RE: Denmark Heights Short Plat, File Number SP-07-109

Kittitas County Community Development Services has determined that the Denmark Heights Short Plat (SP-07-109) is a complete application and hereby grants **conditional preliminary approval** subject to the following conditions:

DENMARK HEIGHTS SHORT PLAT  
 PART OF SECTION 27, T. 17 N., R. 19 E., W.M.  
 KITITAS COUNTY, WASHINGTON

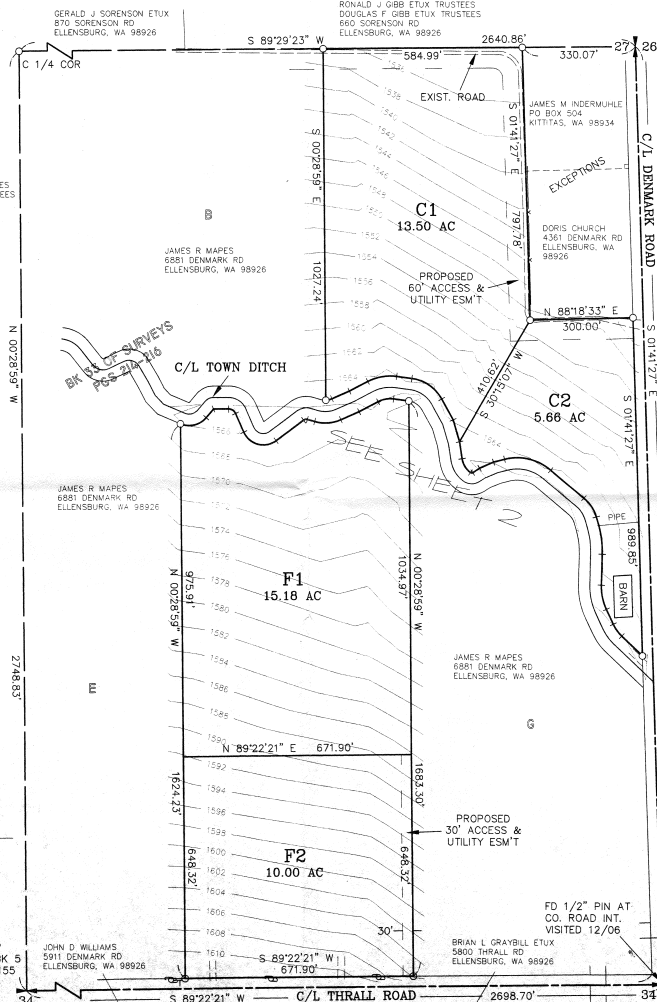
- 1) Both sheets shall reflect Short Plat Number SP-07-109.
- 2) The following plat notes shall be included on the final mylars:
 - All development must comply with International Fire Code.
 - This short plat has exhausted the use of the one-time split provision allowed per Kittitas County Code 17.29.040. No further one-time splits are allowed for the subject parcels and subsequent parcels created via this short plat.
- 3) Attached you will find comments from the Kittitas County Department of Public Works and Kittitas County Environmental Health. **Please see those documents for required plat notes and additional conditions which must be met before final approval of this short plat.**
